Our Ref: AL/34/17/HH
Your Ref:

Town & Country Planning Act 1990 (as amended)
Town & country Planning (Development Management Procedure) (England) Order 2015
Application for Planning Permission for Works or Extension to a Dwelling

Development Single storey extension, car port and new first floor window

Location The Studio Tudor Drive Westergate Aldingbourne

SITE PLAN - SCALE 1:200

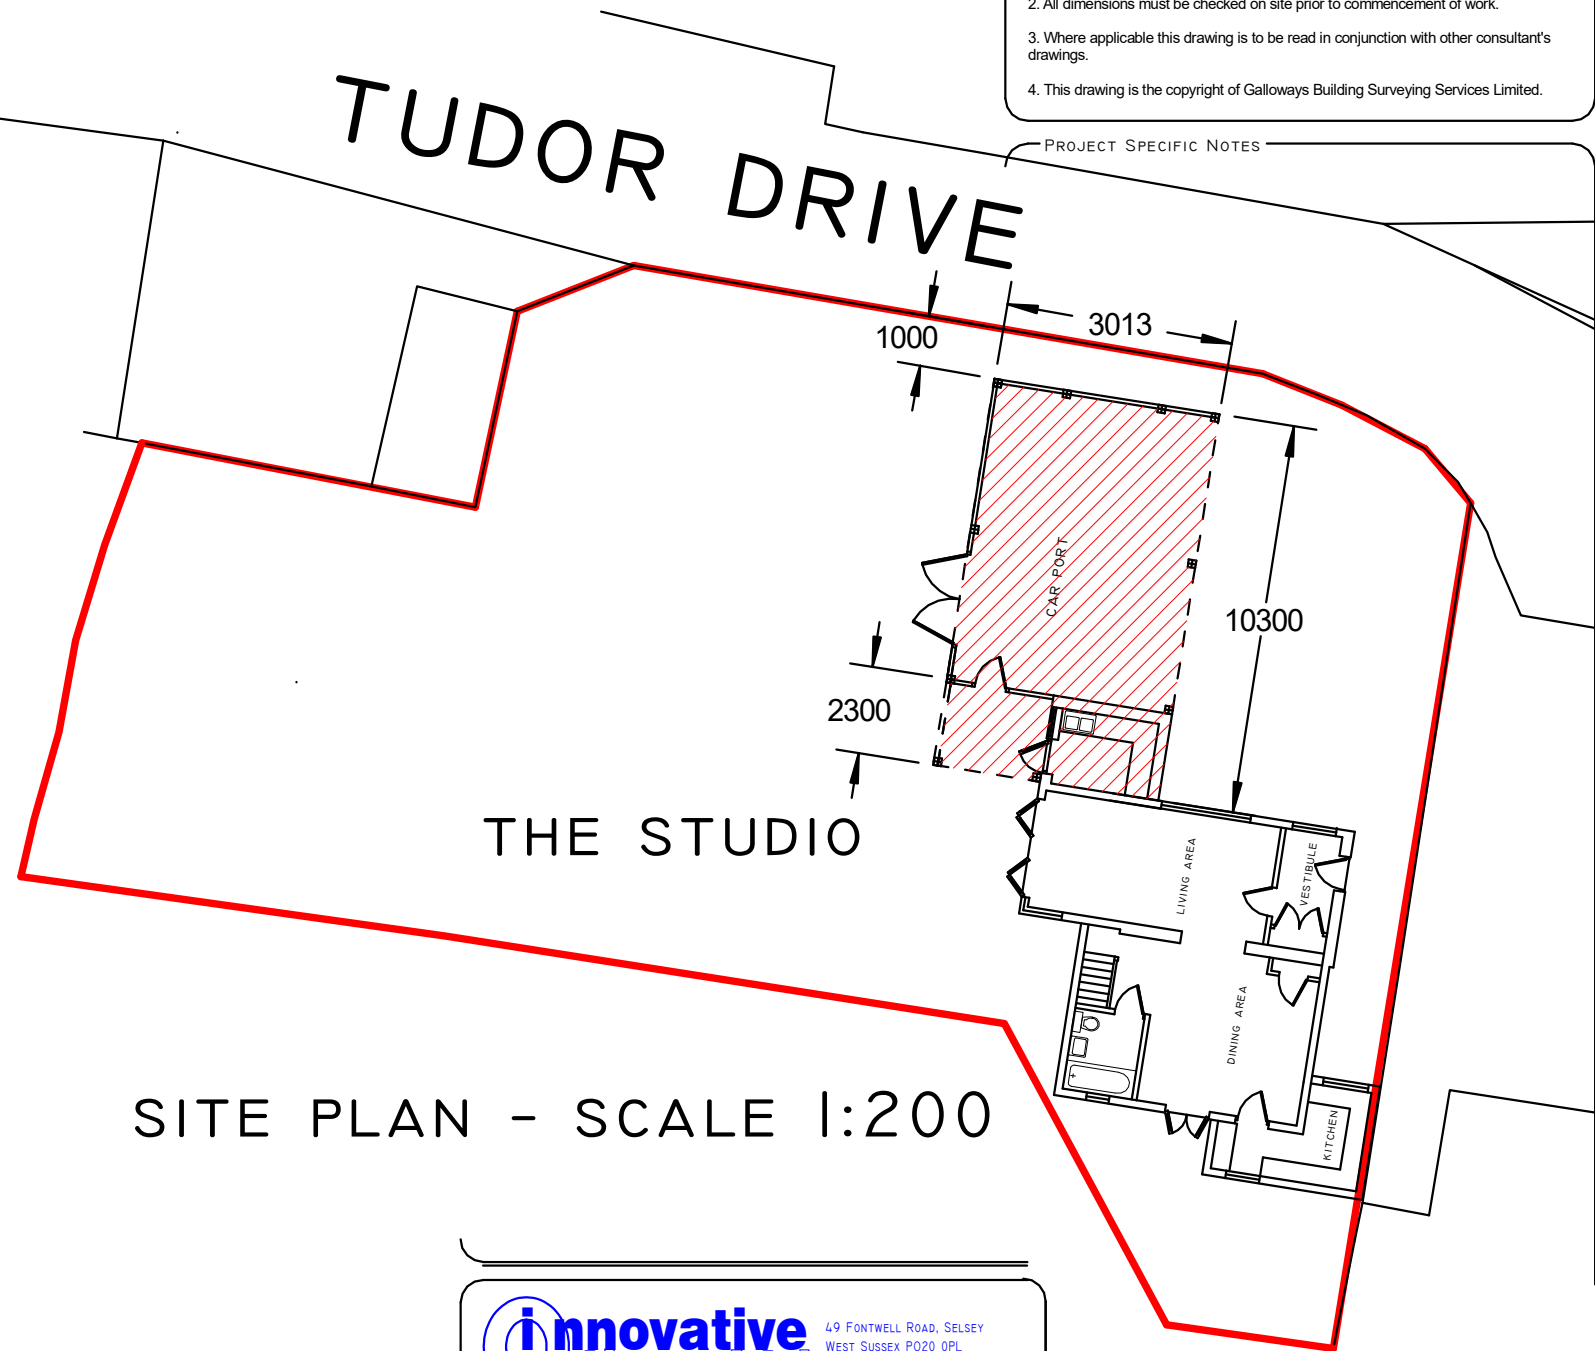
Block Plan

Please annotate the dimensions on the block plan to demonstrate the distance between the proposal and the boundary lines

DRAWING TITLE
FLOOR PLAN
AS PROPOSED

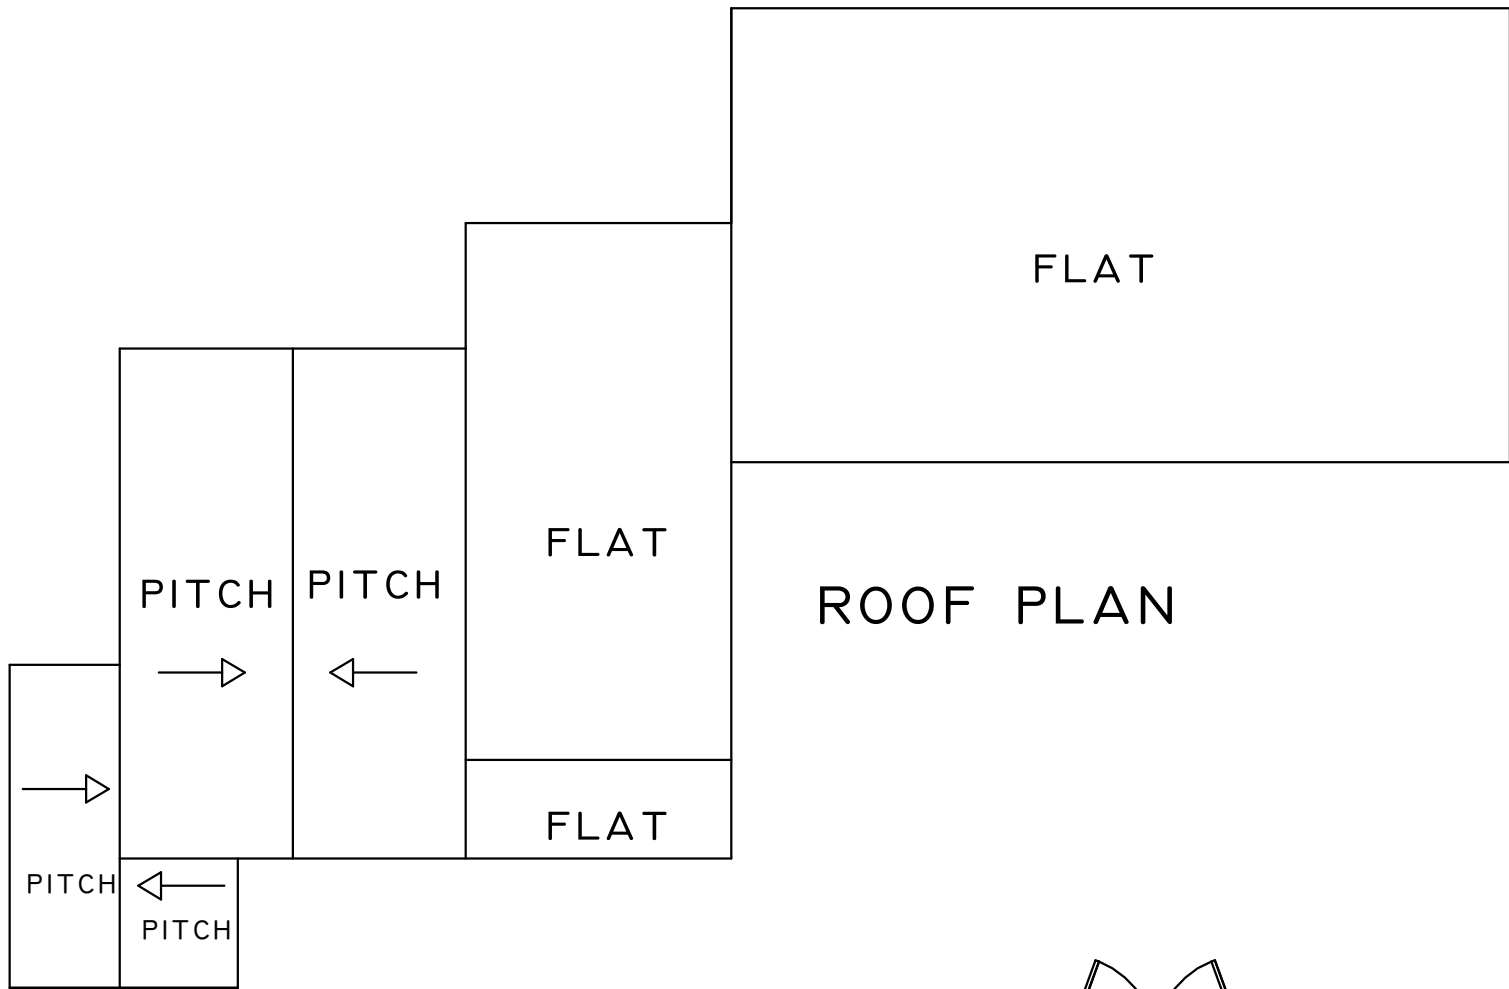
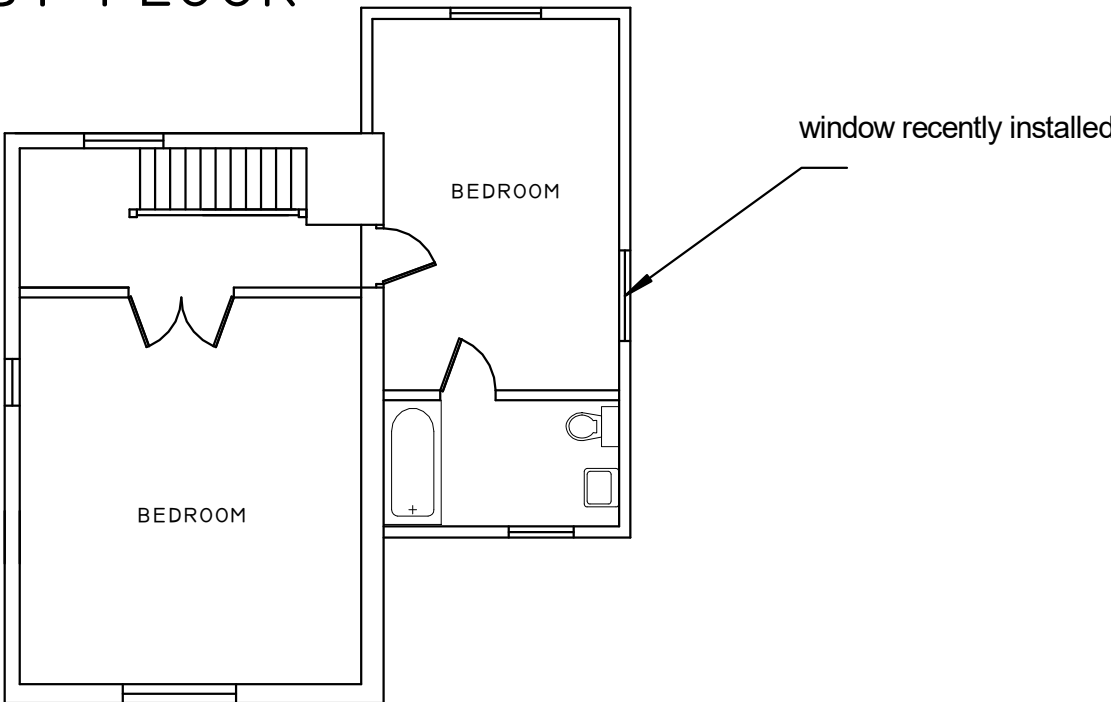
Roof Plan

Please submit 1 electronic or 3 paper copies of existing and proposed roof plan.

DRAWING TITLE
PLANS & ELEVATIONS
AS EXISTING

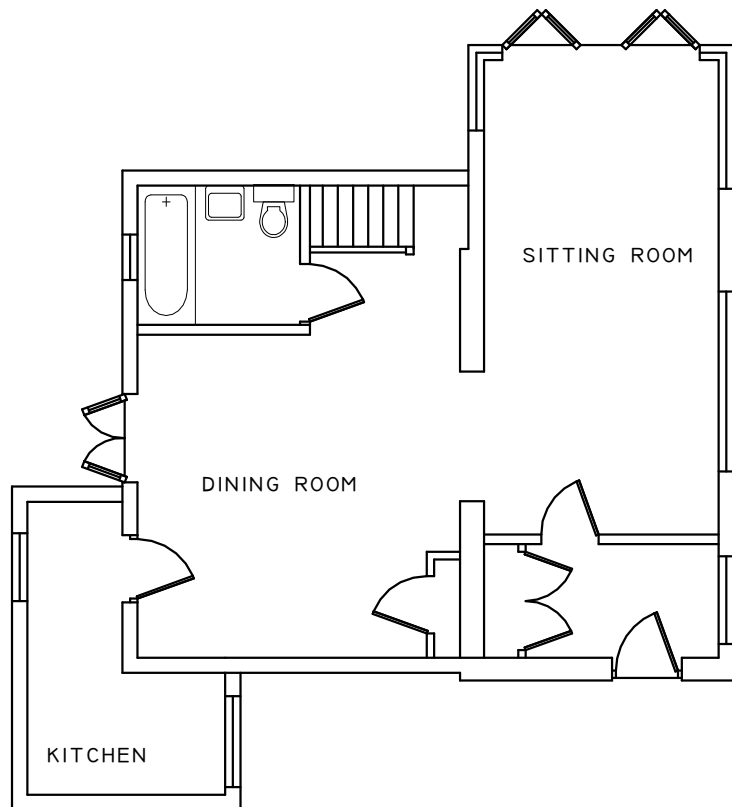
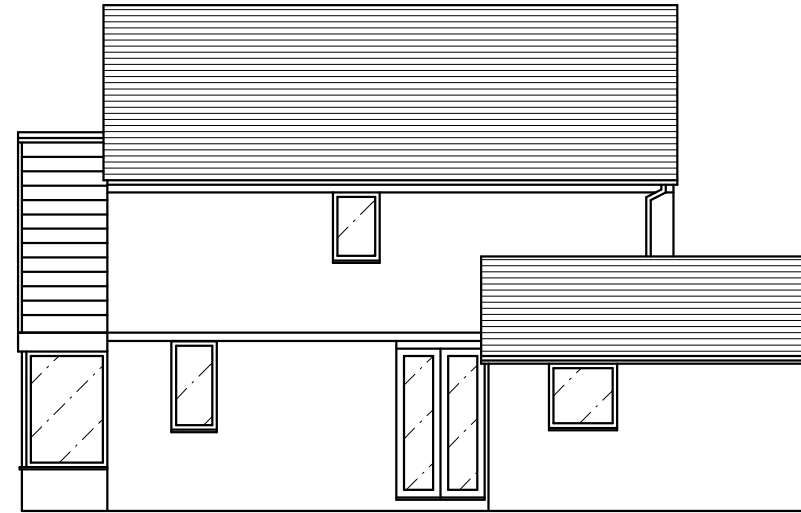
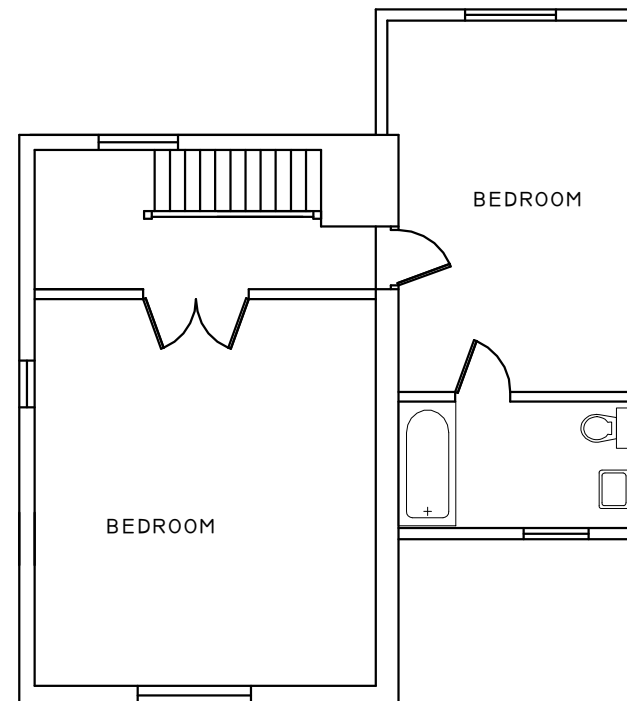
Existing Plans

The existing plans have been cut in two. Please submit as one whole document
